**EL PASO COUNTY PLANNING AND
 COMMUNITY DEVELOPMENT
 DEPARTMENT**

GRADING AND EROSION CONTROL PLAN CHECKLIST

Carriage Meadow South 2

STORMWATER MANAGEMENT PLAN CHECKLIST

SHEET NUMBER  
C4.1

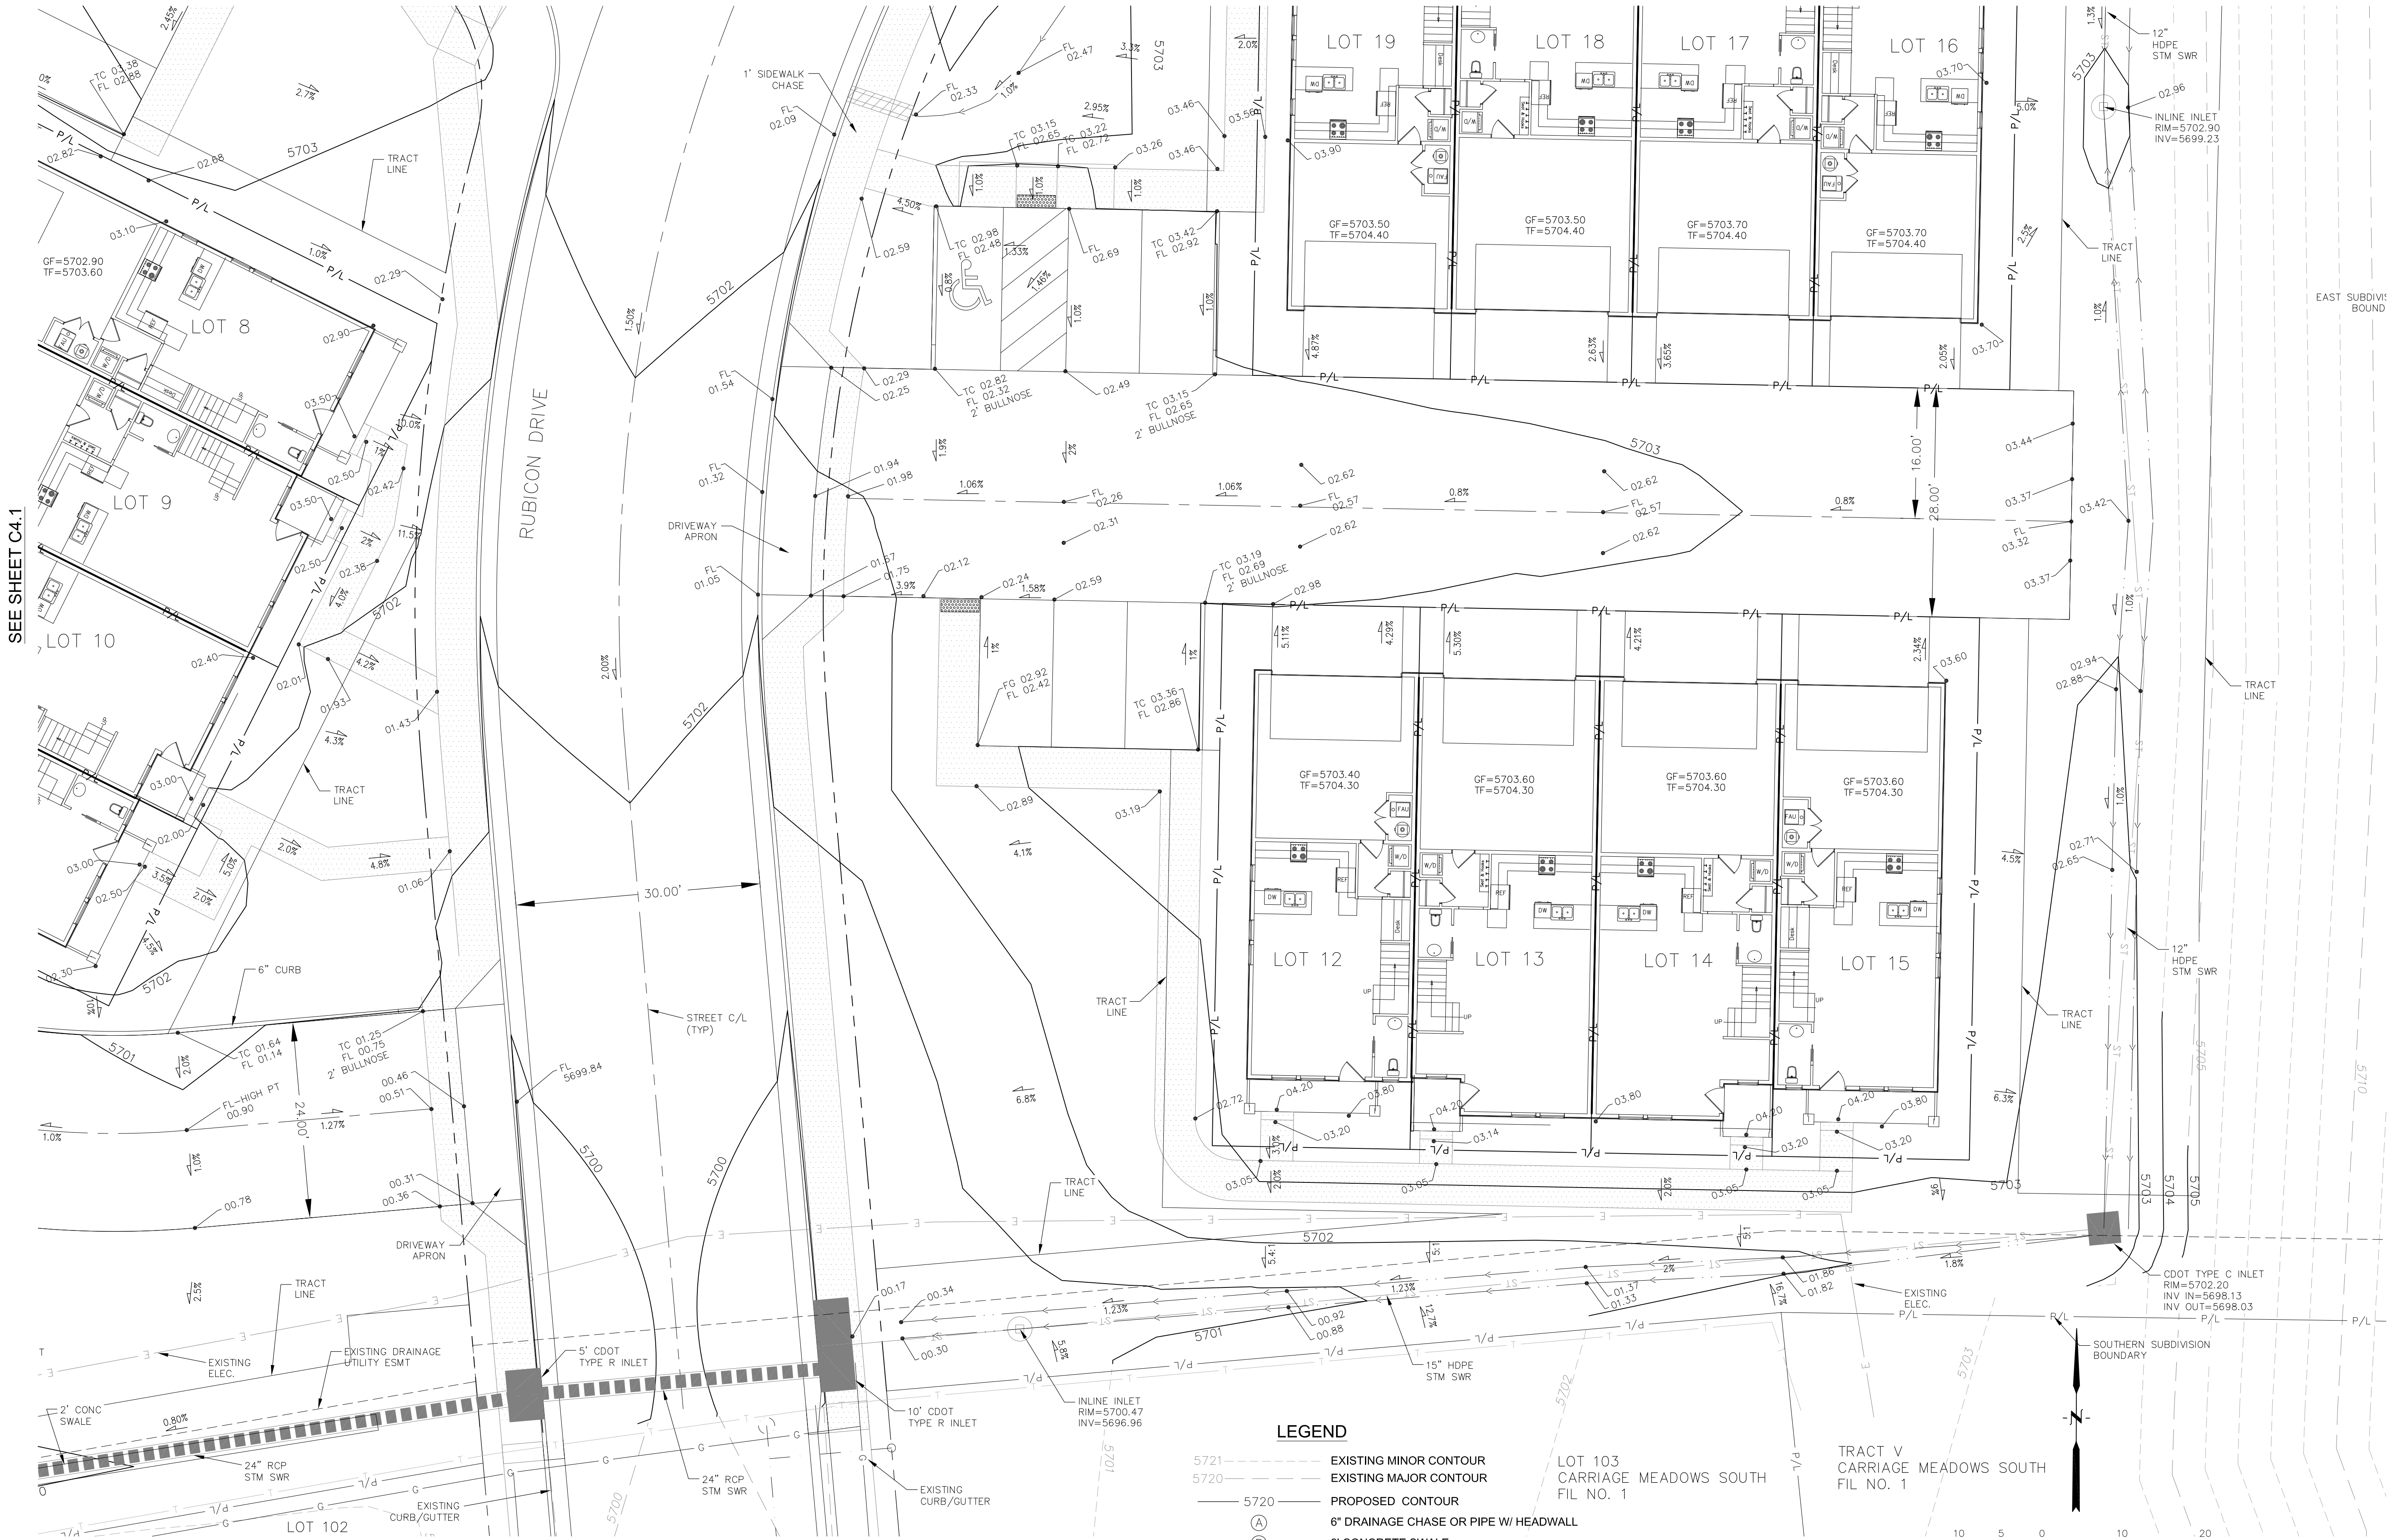
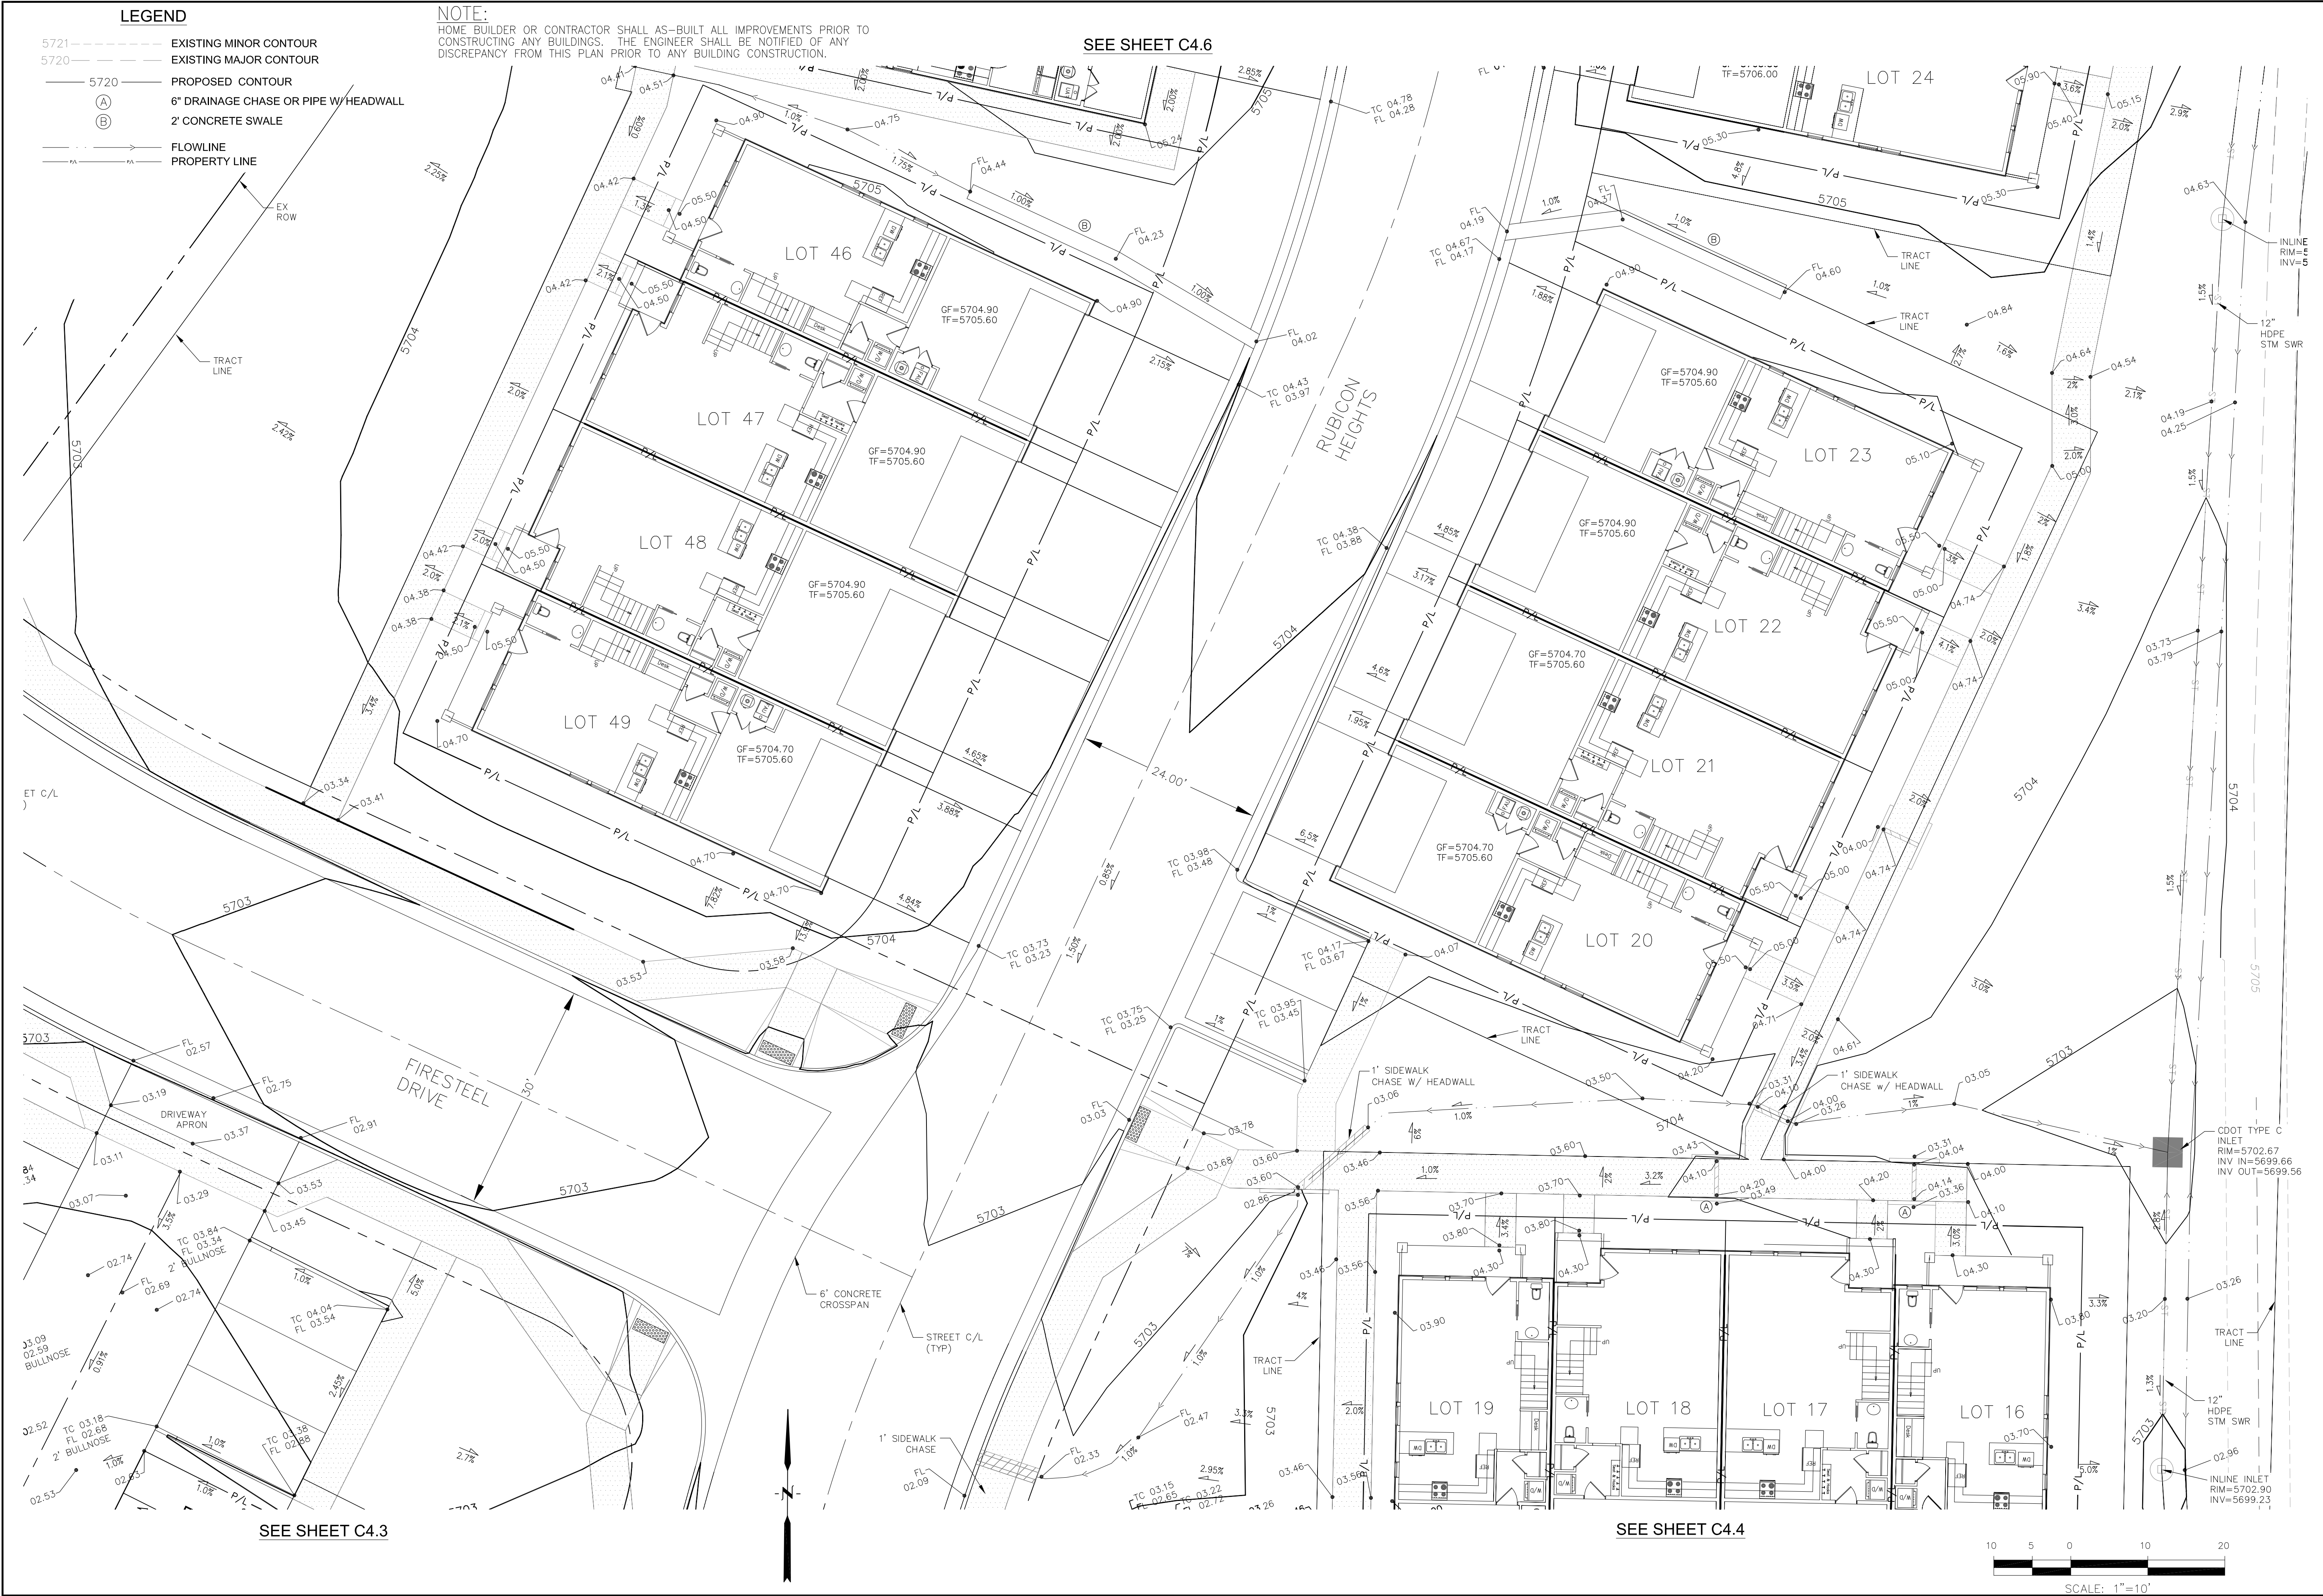
l	Existing and proposed contours 2 feet or less (except for hillside). <i>existing contours should be updated to the current grades for this GEC plan</i>	y	X
m	Limits of disturbance delineating all anticipated areas of soil disturbance.	y	✓
n	Identify and protect areas outside of the construction site boundary with existing fencing, construction fencing or other methods as appropriate.	y	✓
o	Offsite grading clearly shown and called out.	n/a	N/A
p	Areas of cut and fill identified. (See Notes)	n/a	N/A
q	Conclusions from soils/geotechnical report and geologic hazards report incorporated in grading design (slopes, embankments, materials, mitigation, etc.)	y	✓
r	Proposed slopes steeper than 3:1 with top and toe of slope delineated. Erosion control blanketing or other protective covering required.	y	✓
s	Stormwater flow direction arrows.	y	✓
t	Location of any dedicated asphalt / concrete batch plants. (see notes)	n/a	N/A

4. Applicant Comments:			
a	cut/fill areas not needed since entire site is in fill except for small area on east side. Note added to plan		
b	No asphalt batch plans. Note added to plans.
